Re 44\_1724\_BMH

Minor material amendment

**Re: DC/21/121428 land to the rear of 79 Belmont Hill, SE13 5AX**

Drawing Name  
**Proposed Lower Ground Floor Plan**

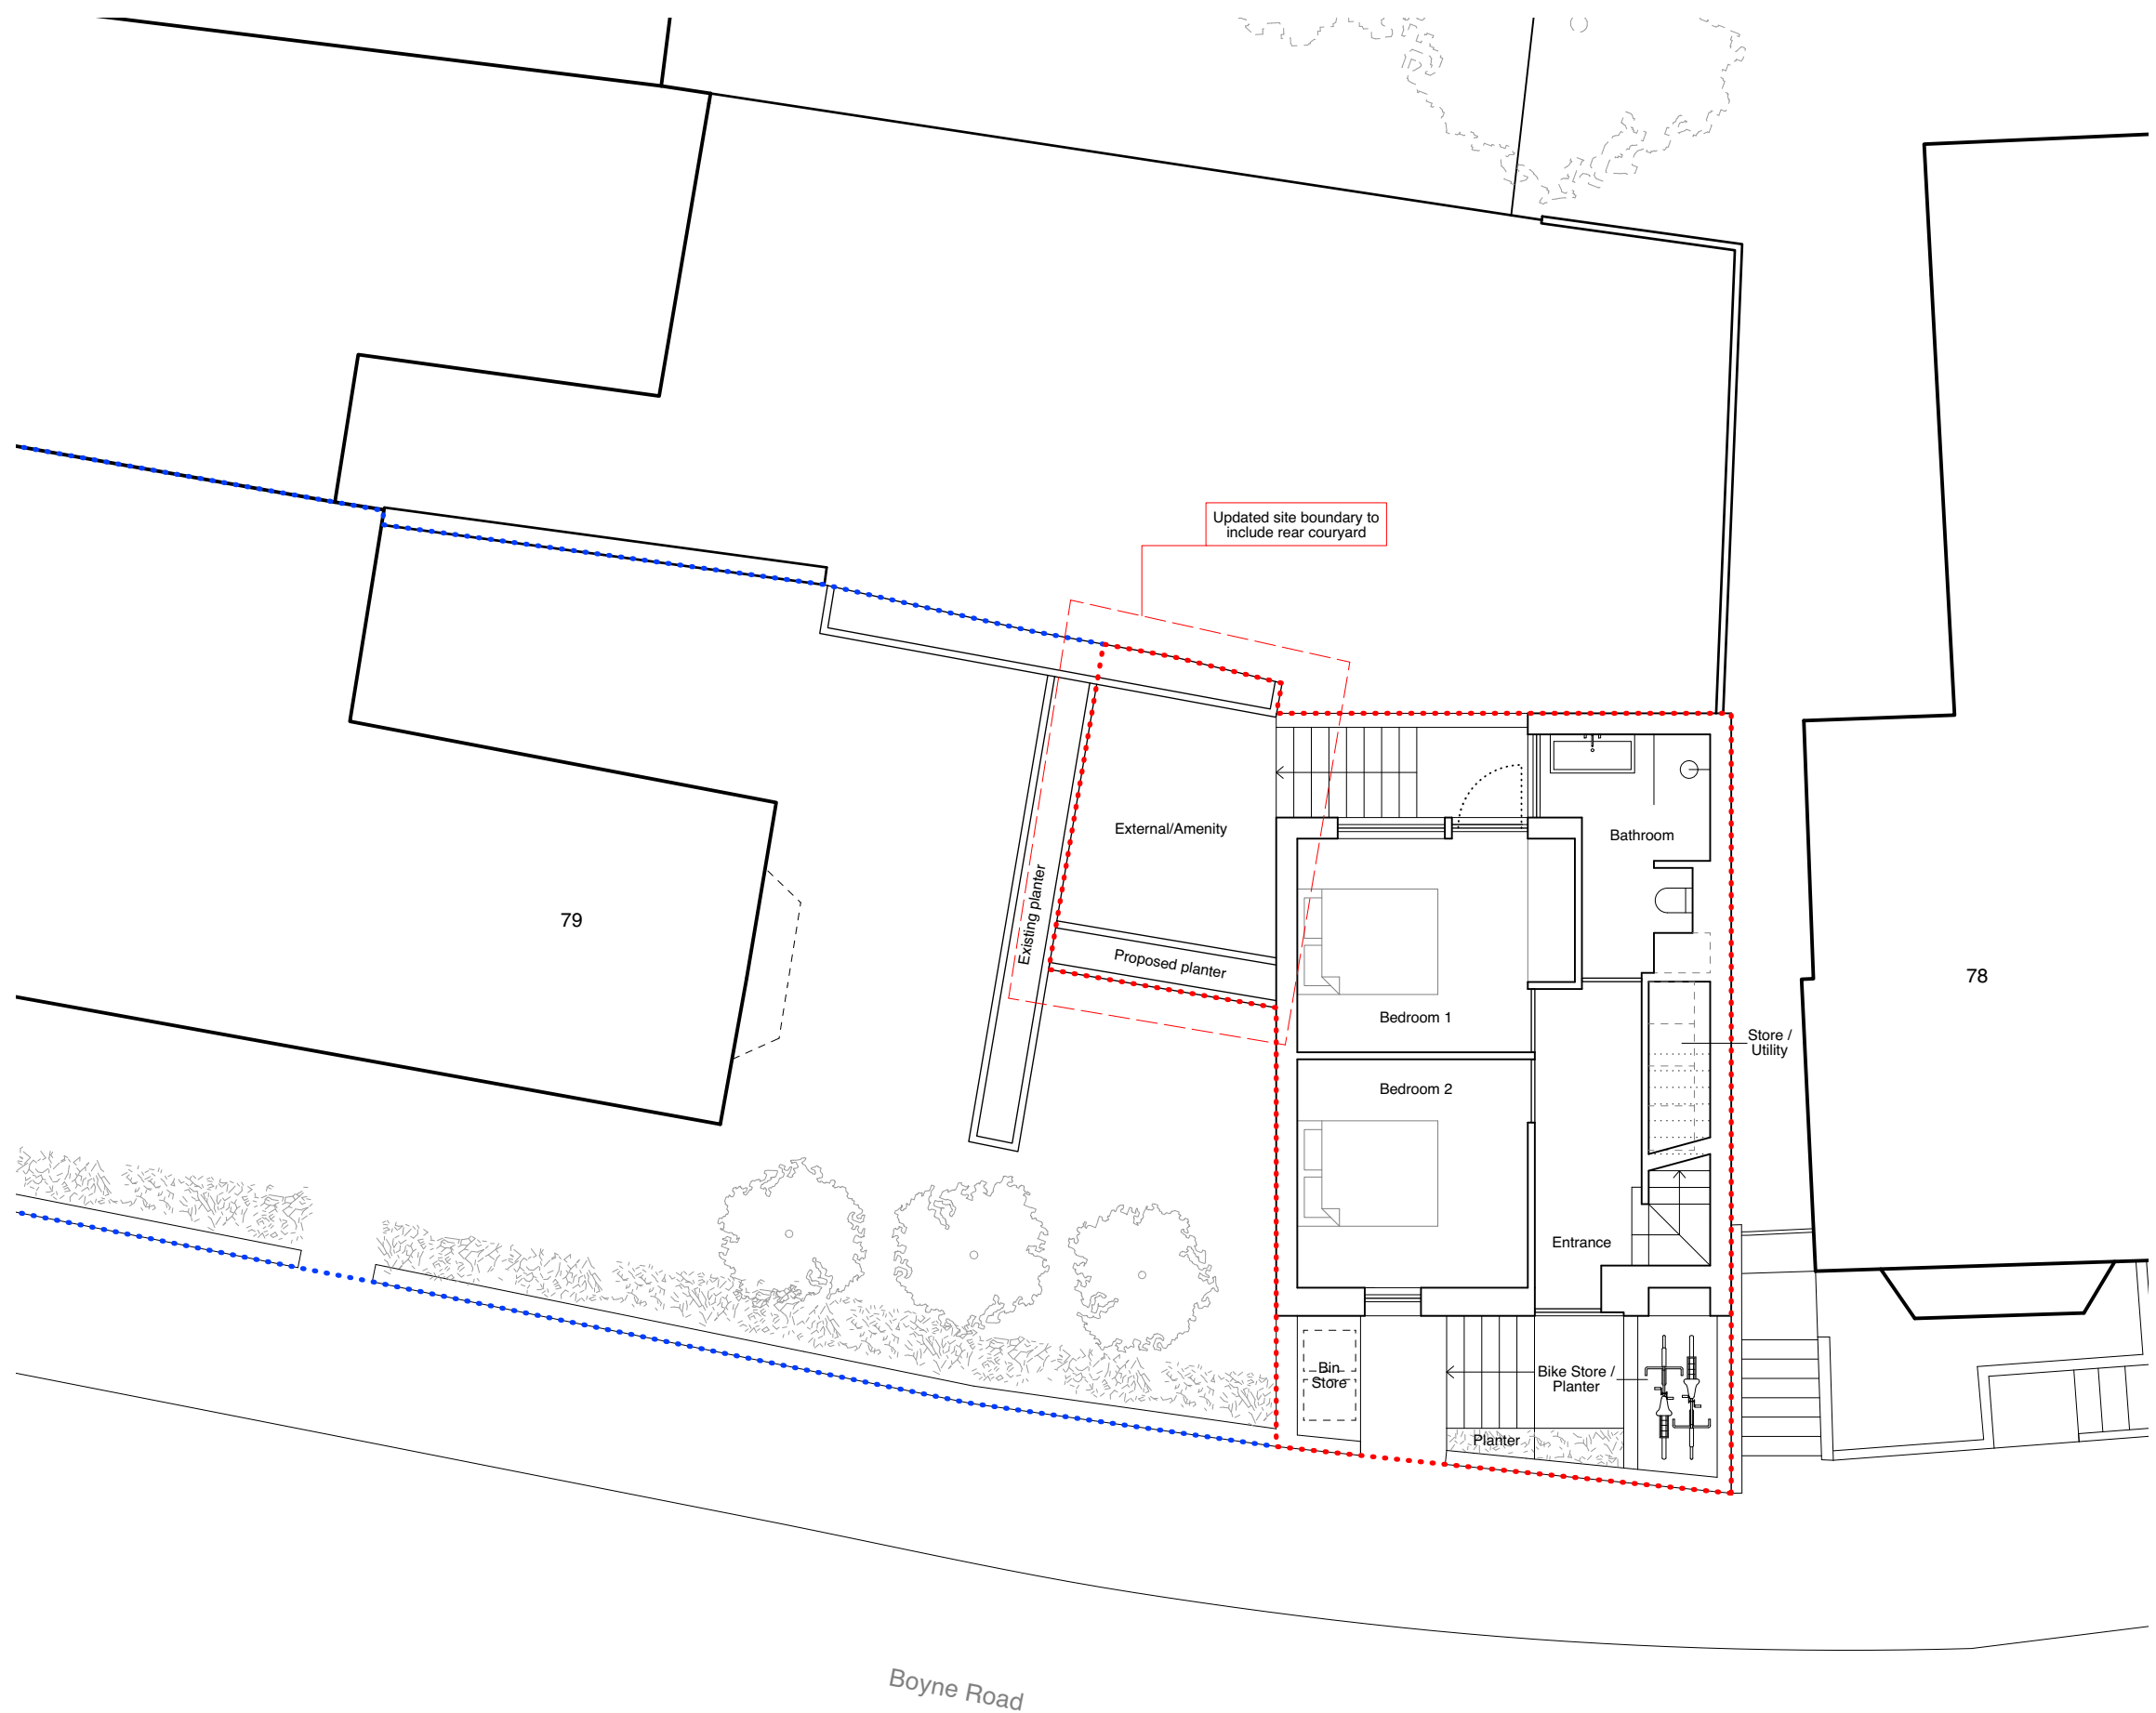
The amendment proposes to extend the lower ground floor courtyard along the southern edge of the property, providing an additional 13.5 sqm of external amenity space with a south-facing aspect. This extra space would come from the amenity space of Flat B, 79 Belmont Hill (also owned by the applicant), with Flat B retaining 25 sqm of private amenity space.

The proposed amenity space would be separated from the adjacent property to the south by an existing planter planted with Photinia hedge. It is proposed that this planter be extended to also form the eastern boundary of the proposed amenity space.

Drawing Name  
**Proposed Upper Ground Floor Plan**

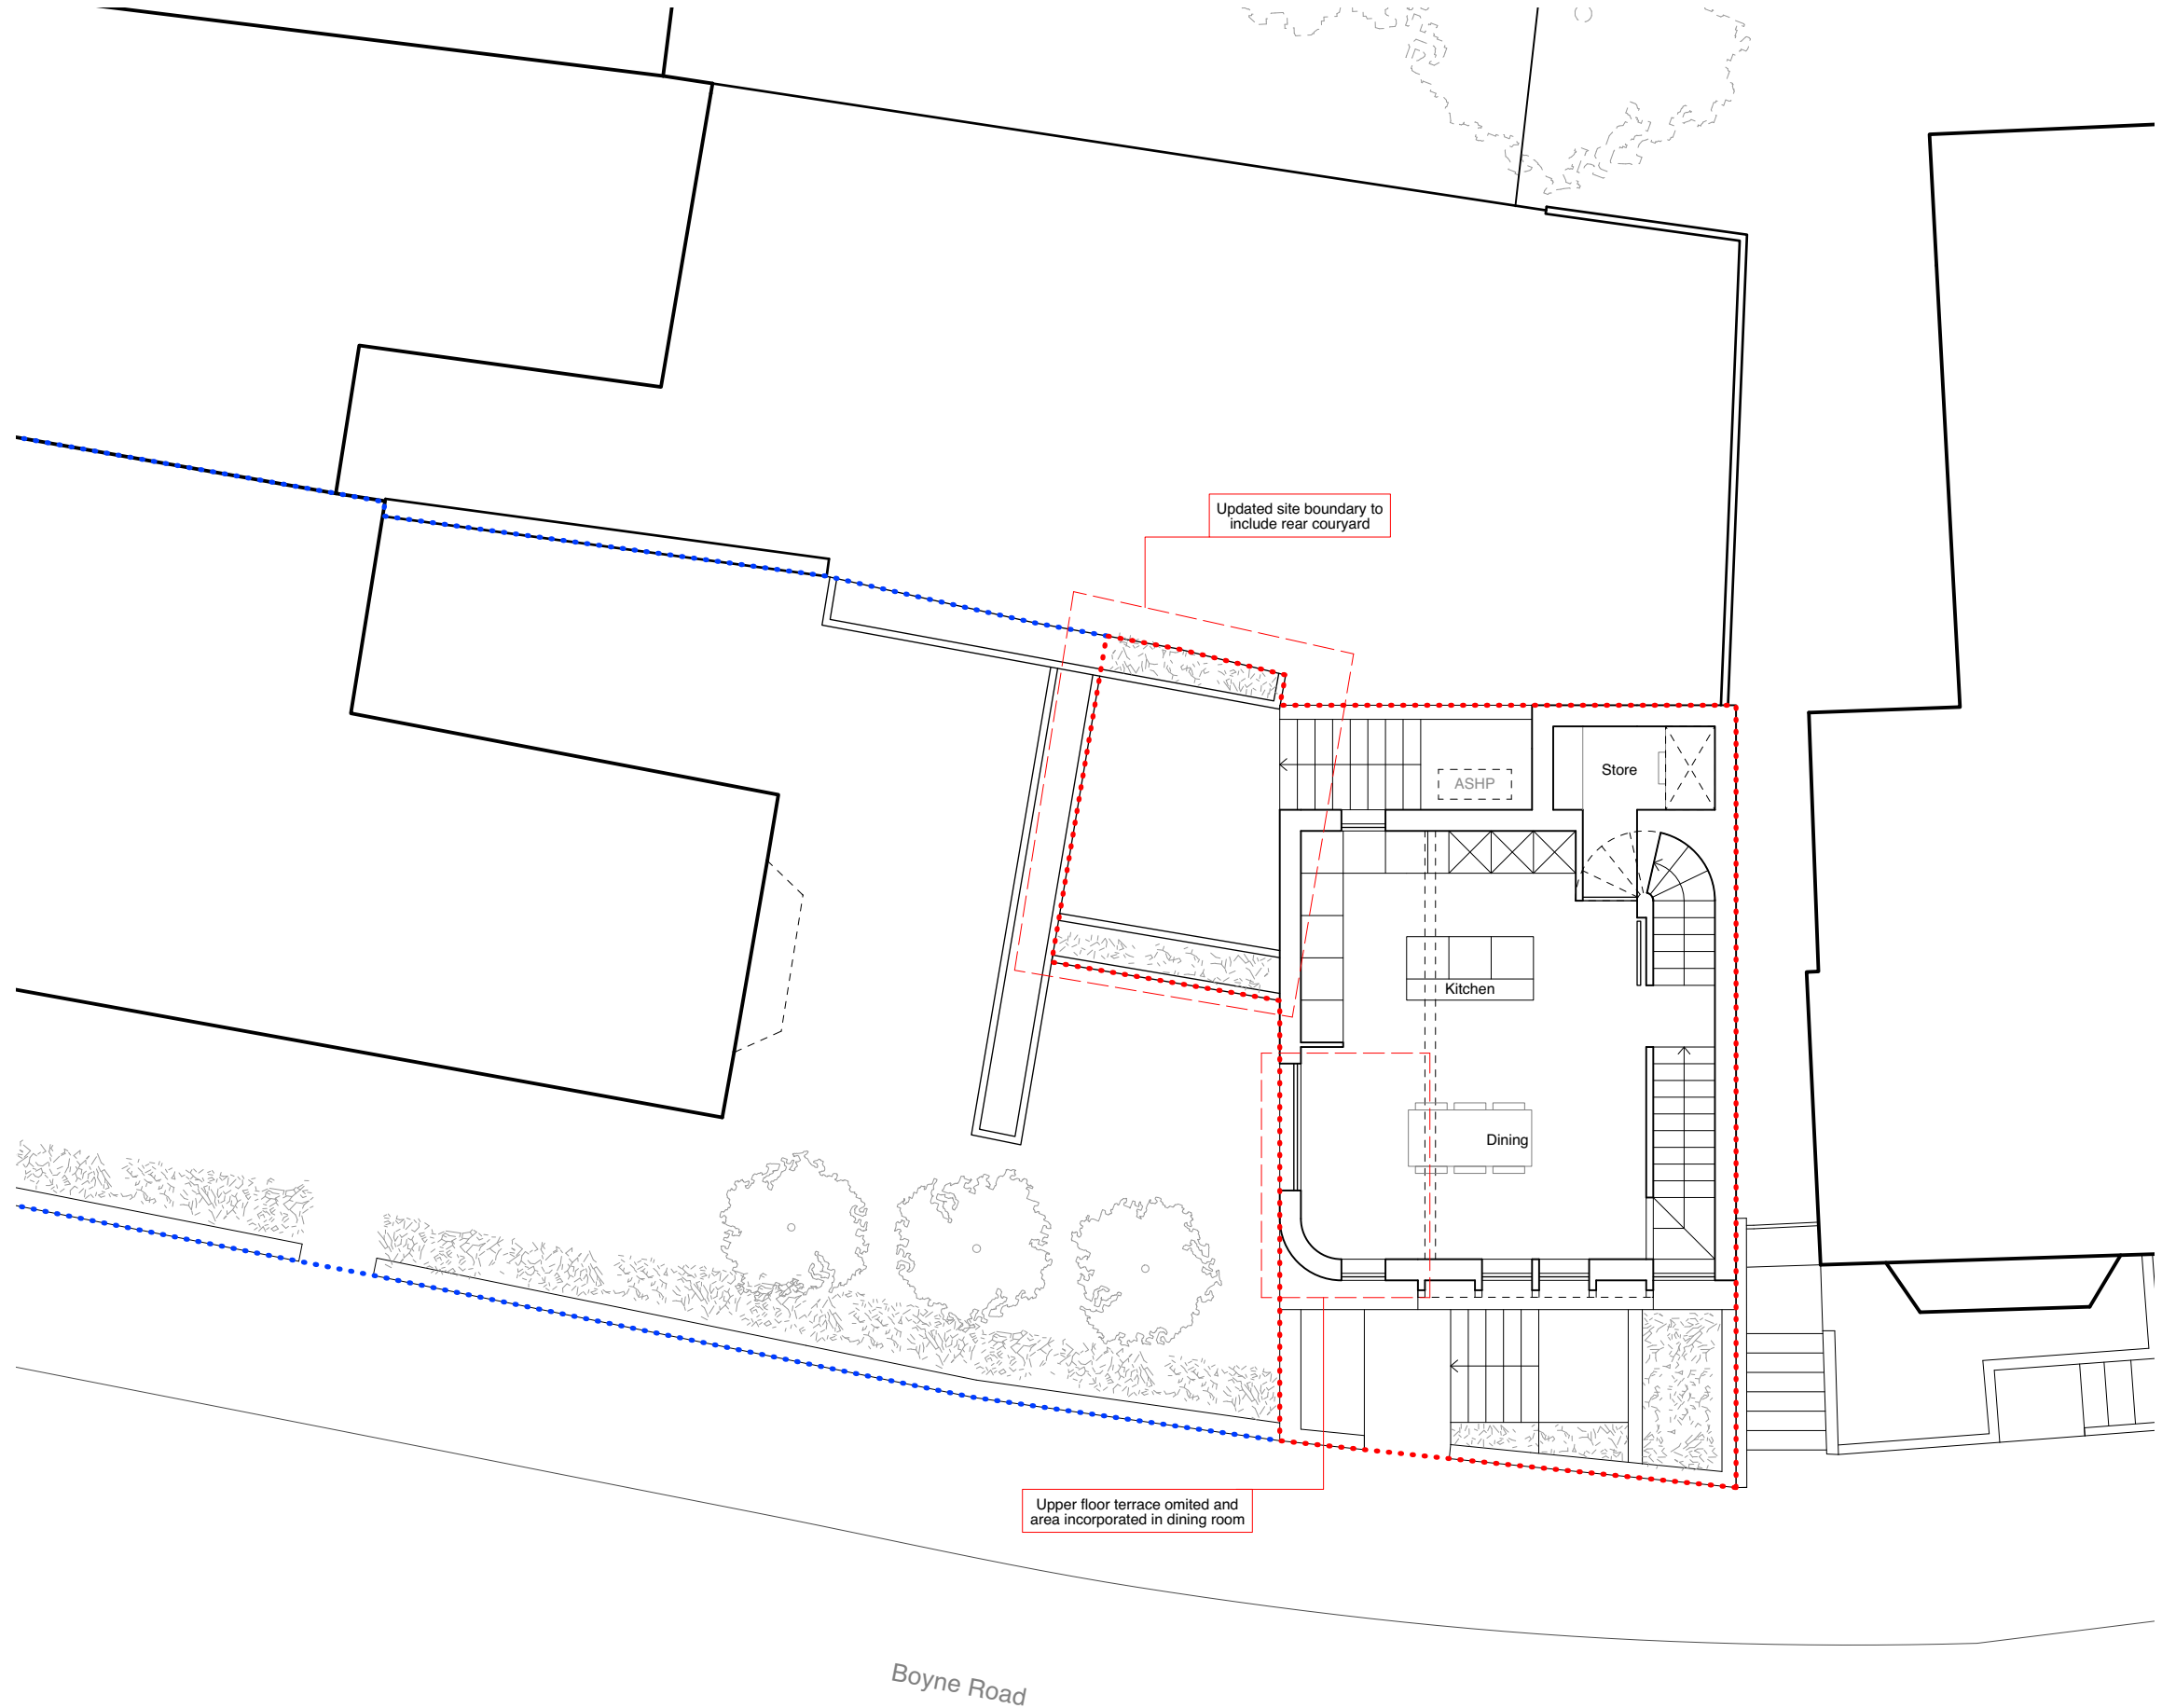
The amendment proposes to omit the upper ground floor terrace incorporating the space into the kitchen dining room. The omission of the 3.5 sqm terrace as external amenity space is positively offset by the proposed extension to the lower ground floor courtyard described above, resulting in a nett increase of 10 sqm of external amenity space. The internal area of the kitchen dining space would increase by 5.5 sqm, and the squarer proportion of the room would improve the usability of the space and flexibility in terms of furniture arrangement.

Externally the proposed amendments are minor. The location and amount of glazing is maintained, but wherein the consented design there are single panes of glazing enclosing the roof terrace, there are now fixed triple glazed units.
